Rezoning Transportation Analysis

Petition Number: 2020-112

Revision Log:

Date	Description
09-11-20	First Review

RZ-4.0

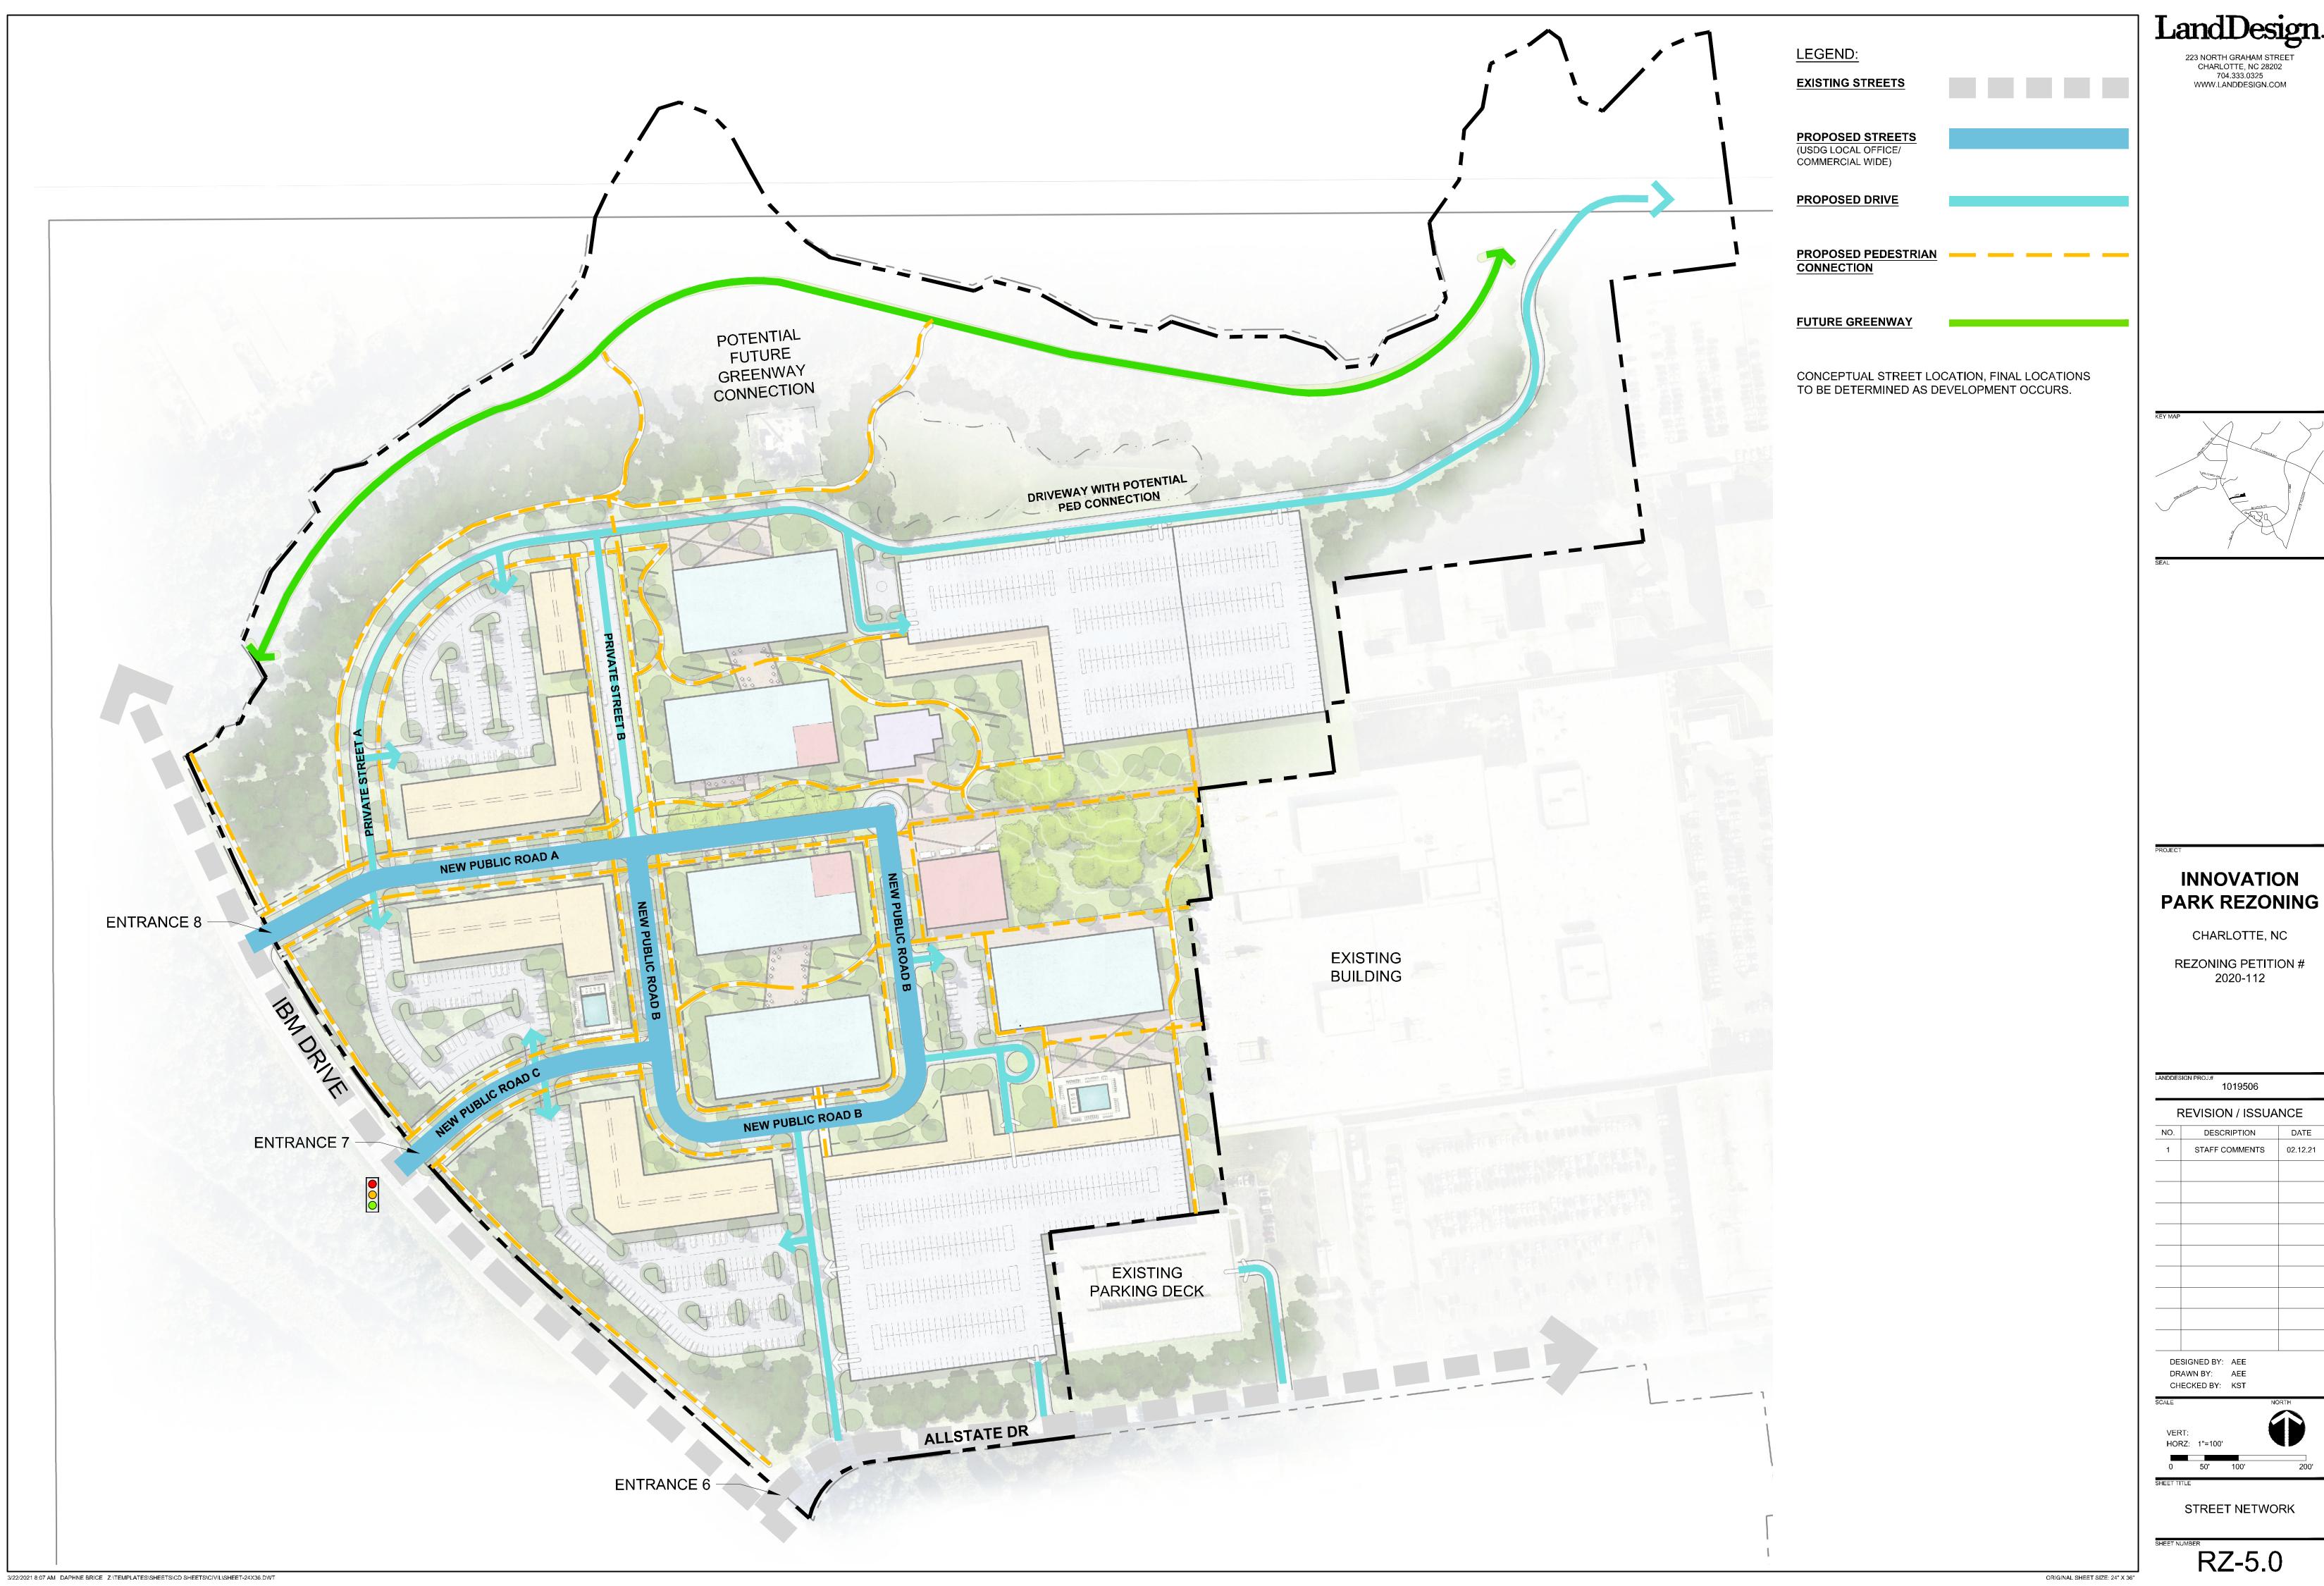
- a. **IBM Drive:** The future location of curb and gutter is at its existing location.

- a. The site plan and conditional note(s) need to include the TIS roadway improvement mitigations within **(Section 5)** of the conditional notes.
 - b. The site plan and conditional note(s) **(Section 5.E)** need to be adjusted to the proposed phasing of transportation improvements to the phasing that is approved within the TIS.
3. Confirm that a minimum of 35-feet of right-of-way is dedicated from the existing IBM Drive road centerline, labeled and dimensioned from the road centerline.

- The petitioner needs to revise the site plan's conditional note, under '2 Optional Provisions H' to include the construction of a 12-foot Multi-Use Path. CDOT requests construction of bicycle facilities by installing an 8-ft planting strip and 12-ft Multi-Use Path along IBM Drive to meet the City Charlotte BIKES Policy. The construction of the Multi-Use Path may be phased, according to the development of each proposed development area. Charlotte BIKES Policy supports a Multi-Use Path as an appropriate bike facility due to topography, connections to an emerging greenway network, and limited driveways. If the Multi-Use Path is difficult to implement with an 8-ft planting strip; a 14-ft back-of-curb multi-use path may be considered, due to site hardship.

- The site plan and conditional note(s) need to establish a street connection, as shown below, according to the proposed avenue cross section that is recommended within the University Research Park Area Plan. Refer to pages 38 and 41.

- Add a note to the site plan specifying dedication and fee simple conveyance of all rights of way to the City before the site's first building certificate of occupancy is issued. CDOT requests right-of-way set at 2' behind back of sidewalk where feasible.
- Provide additional street connectivity to the north leg of the existing roundabout at the intersection of IBM Drive and University Pointe Boulevard, in the event the existing warehouse use circled below is removed or replaced. These street connections are important to redistribute traffic to multiple access points along IBM Drive.
